Re: 19-143 Rye Park Wind Farm Modification Aboriginal Cultural Heritage Assessment

NGH would like to advise of two inconsistencies within the Aboriginal Cultural Heritage Assessment (ACHA) report, supplied by NGH to Tilt Renewables in April 2020, and Addendum report supplied to Tilt Renewables in August 2020. The inconsistencies relate to two sites in the impact assessment tables provided in the report. Below is an explanation of the issue and the change required to correct the record.

Table 3: Aboriginal heritage items – undertake salvage excavations

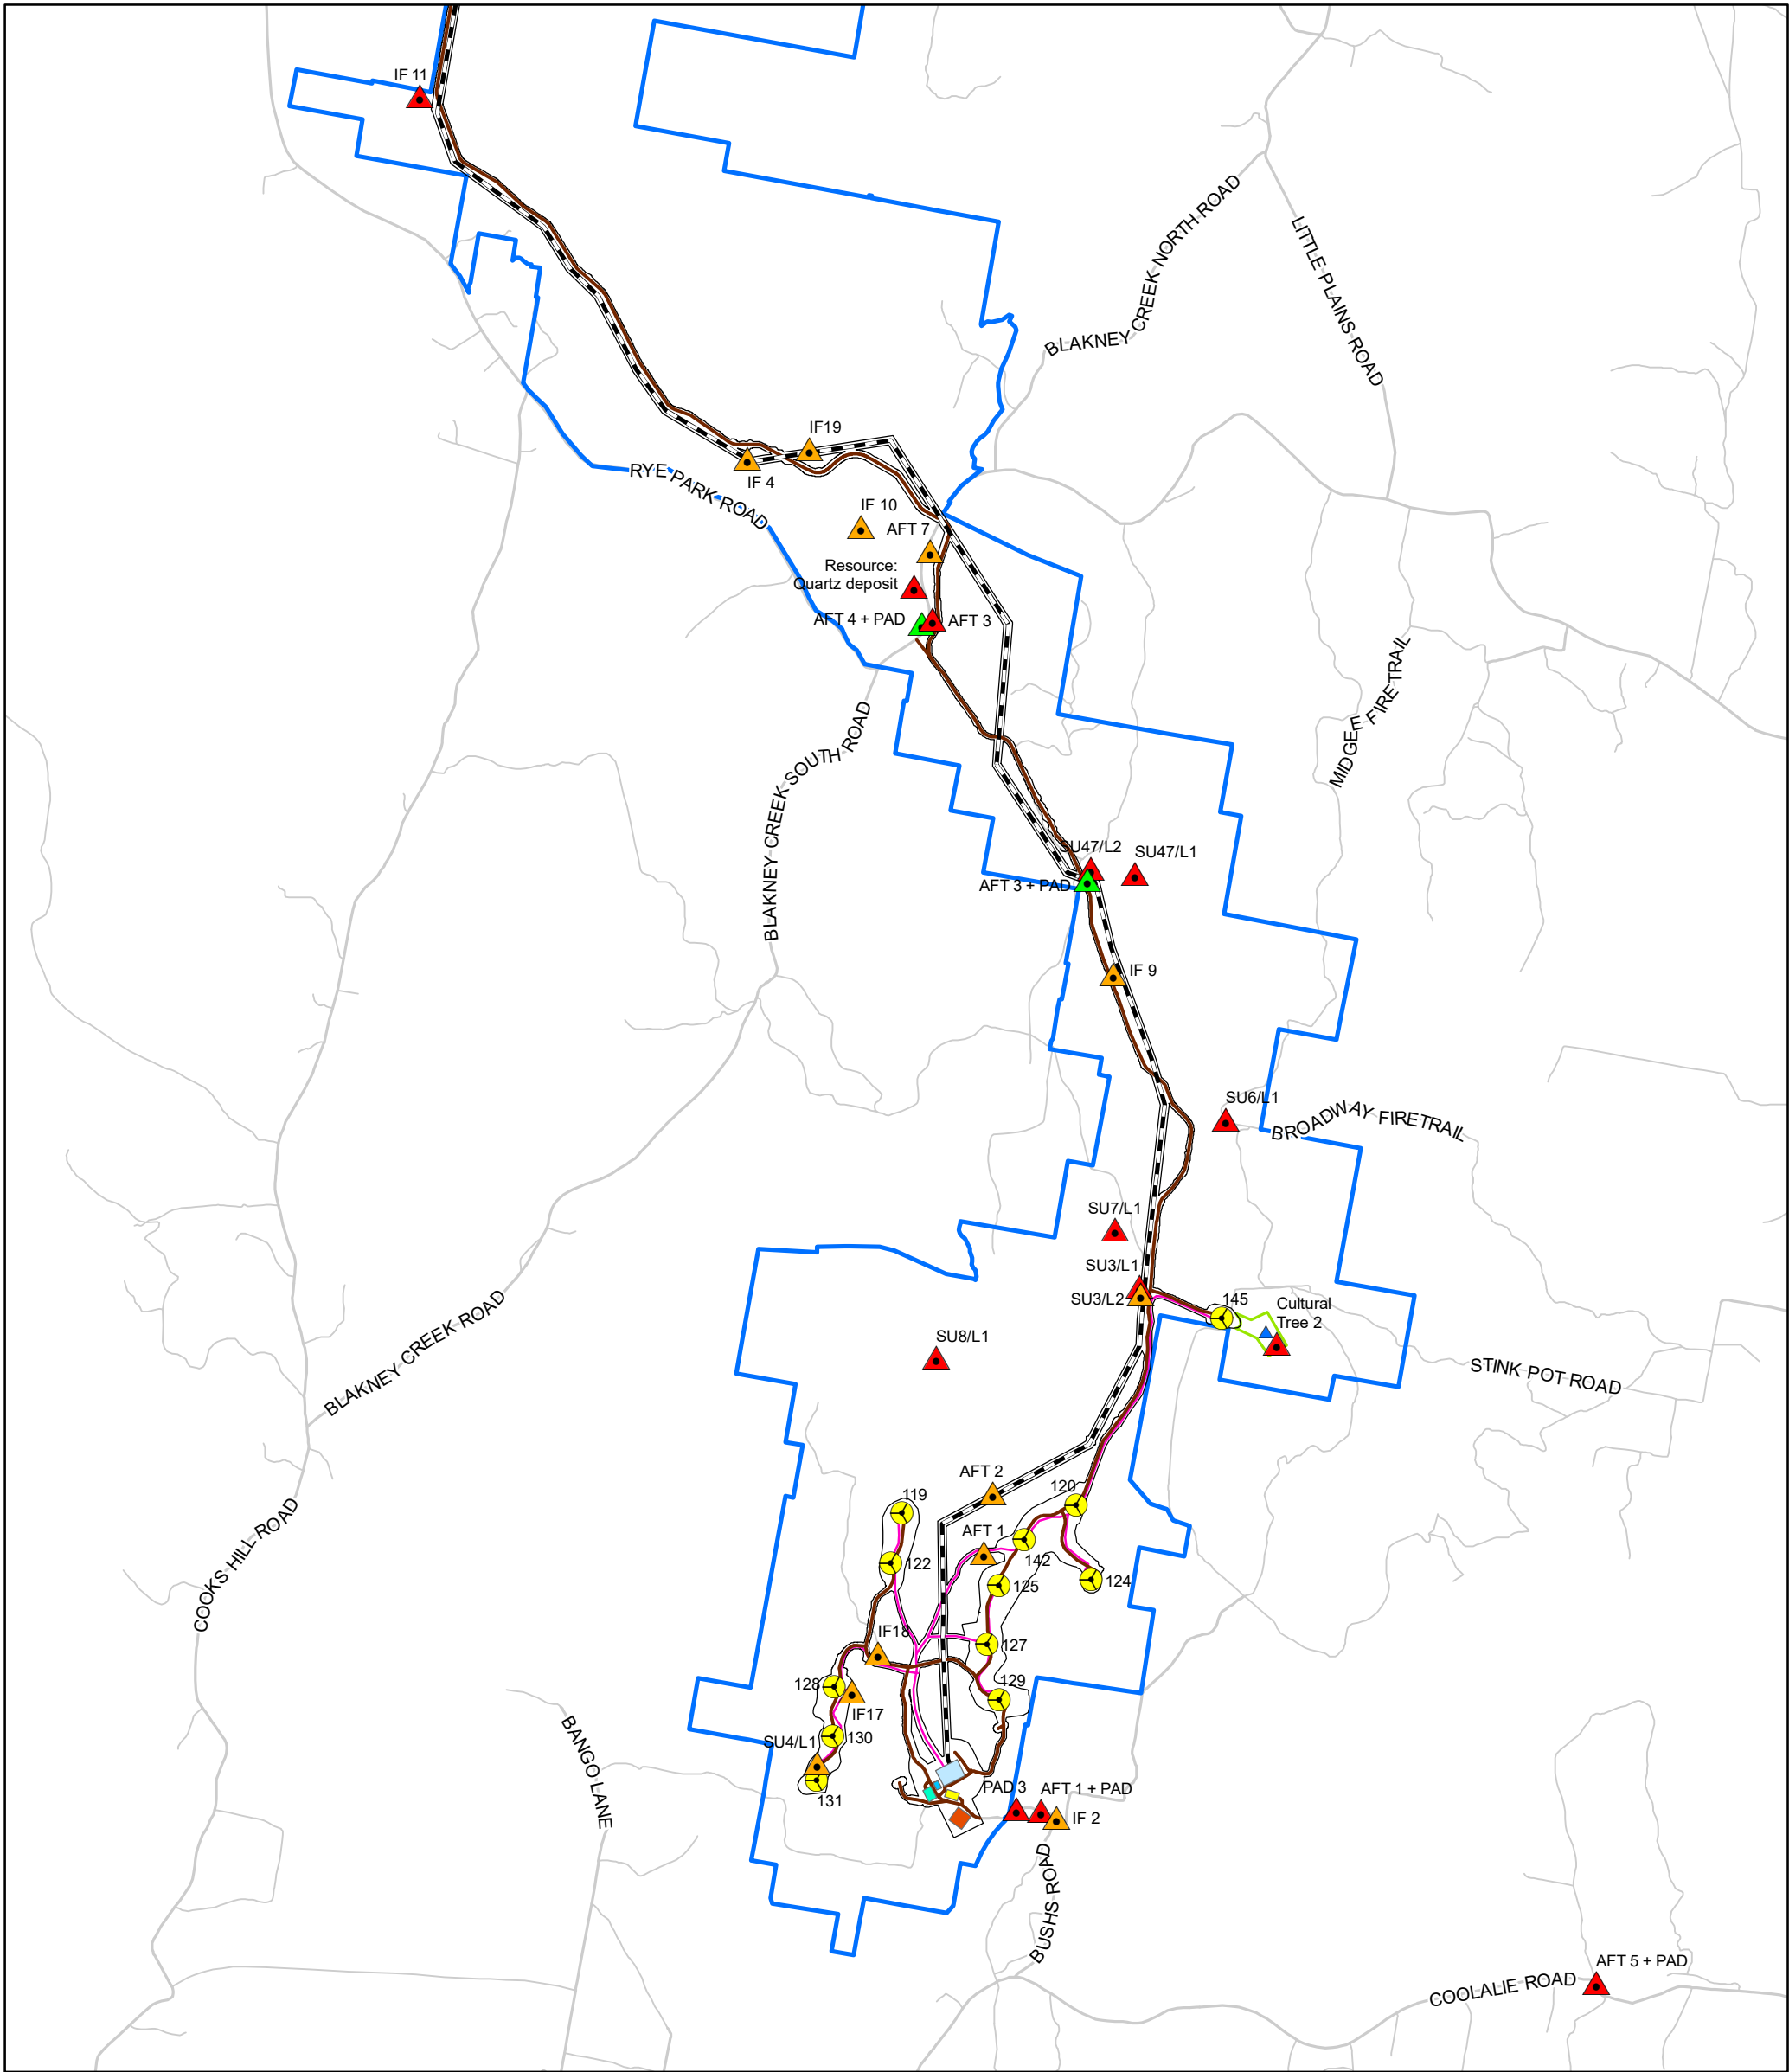
Table 7-1 (pp. 81-96) of the ACHA report (2020), outlines the identified risk to known Aboriginal heritage sites. Within this table (pg. 88), the description associated with IF10 incorrectly describes the site as including a Potential Archaeological Deposit (PAD). As a consequence, the recommendations include the need for salvage excavations at the location, if impacted. This is an error in the site type as there is no PAD associated with IF10.

This error has also been repeated in the Modification Application (submitted April 2020), where Table 3-6 *Aboriginal heritage items – excavations* also incorrectly identifies the recommendation for IF10 as Minimise/Undertake salvage excavations.

Table 3-5 *Aboriginal Heritage Items – minimise impact* of the Addendum report (pg.17), has an error in the outlined impact of site IF4. This site is an isolated surface artefact, which has been incorrectly listed as requiring salvage excavations if impacted. This is an error in the recommendations as there was no subsurface potential identified.

This error also occurs in Table 2 of the Modification Application (submitted April 2020), *Aboriginal Heritage Items – minimise impact*.

The site IF10 will need to be removed from the table *Aboriginal heritage items – excavations* and added to the table *Aboriginal Heritage Items – minimise impact*, with the impact details updated to minimise / undertake surface salvage. See updated tables below.

The site IF4 is listed in the correct table (3-5), however the details in the impact column will require updating to reflect the correct recommendation, minimise / undertake surface salvage (as shown below).
